Subject: [Ext] Notice of Application SE-20-00009 Kittitas County Ryegrass Facility

TO: All Staff
FROM: Public Works Planning Review Team
DATE: December 17, 2020
SUBJECT: SE-20-00009 Kittitas County Ryegrass Facility

Ryegrass Application Fields

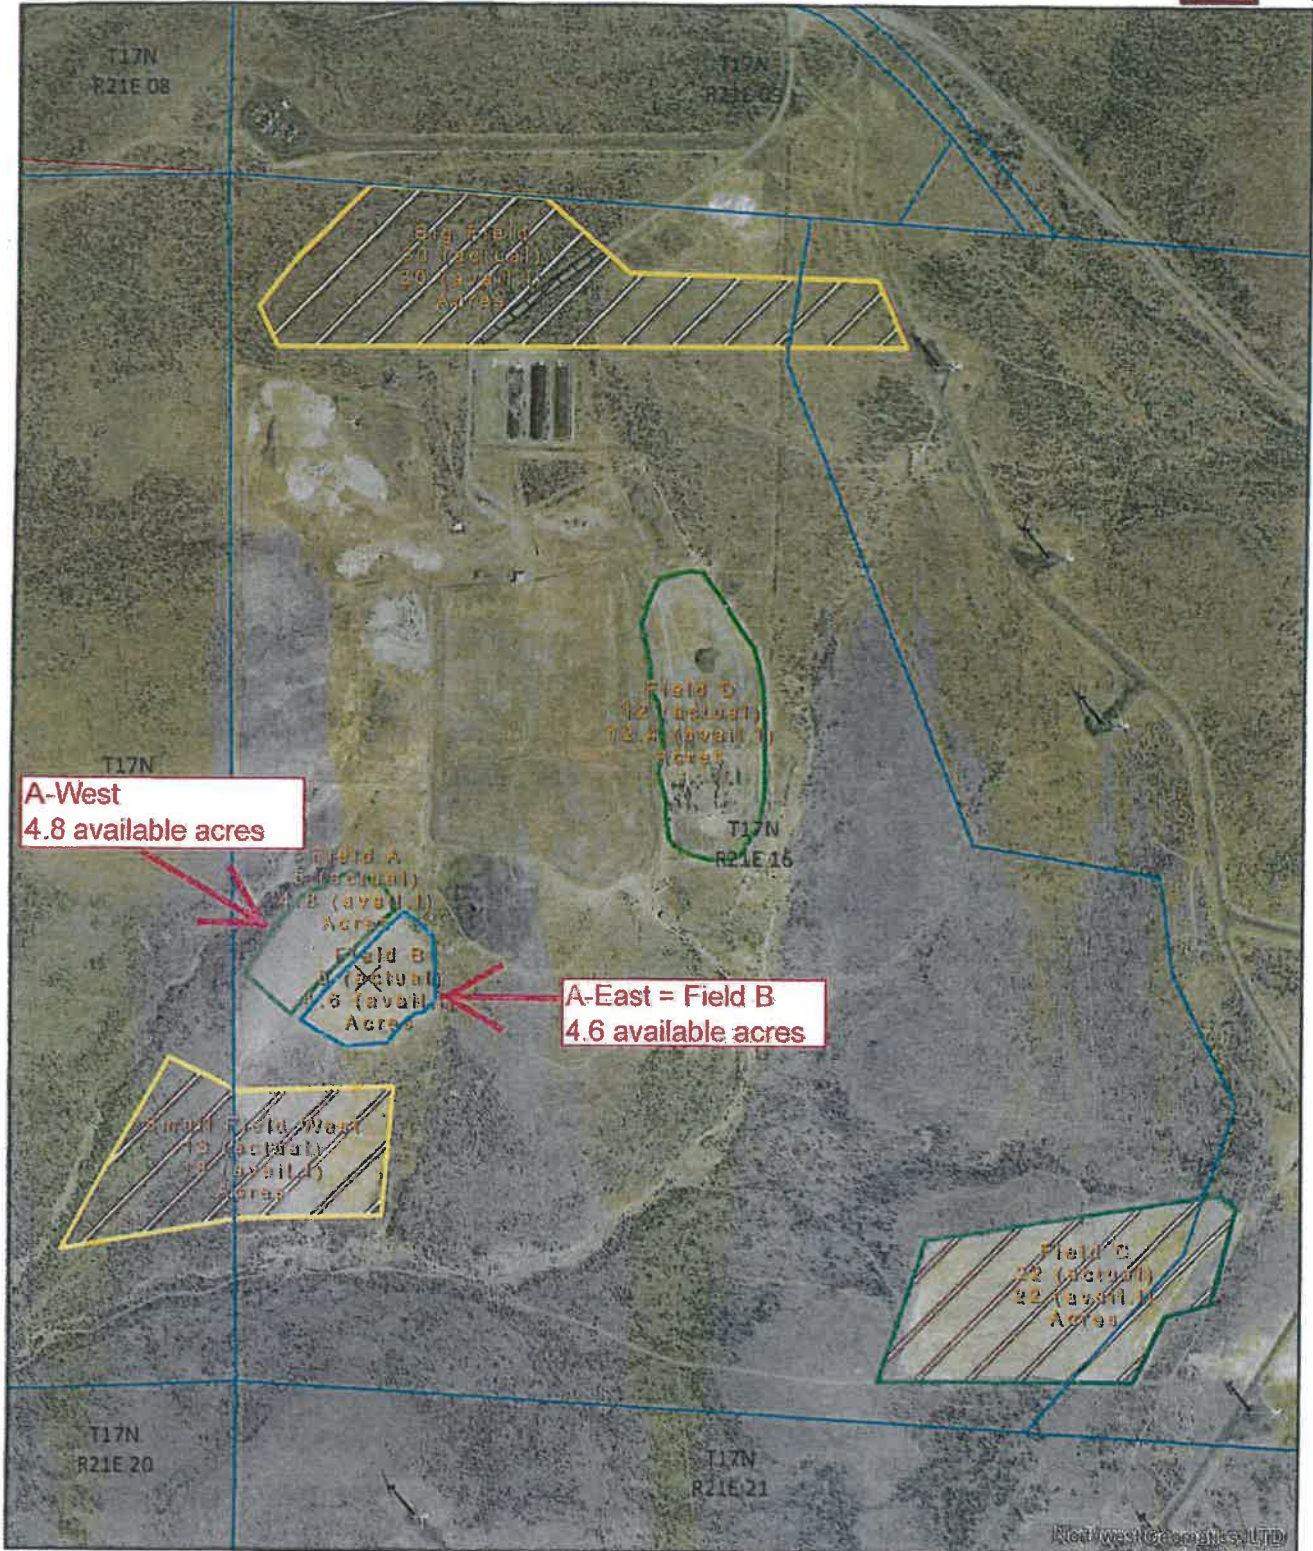
1. In between the application areas, there is sagebrush areas, which is a diminishing and priority habitat in the county. WDFW would like to see no new clearing of sagebrush in this area (so application limited to already cleared areas). If additional clearing must occur, then consulting with WDFW for mitigation to clearing would be encouraged.
2. When these fields were originally cleared, they likely contained sagebrush as evidenced by the surrounding areas containing sagebrush. When the fields are no longer desired to be used for this biosolid treatment, WDFW would recommend that sagebrush would be planted as part of a restoration plan as that would help to improve habitat in the area.
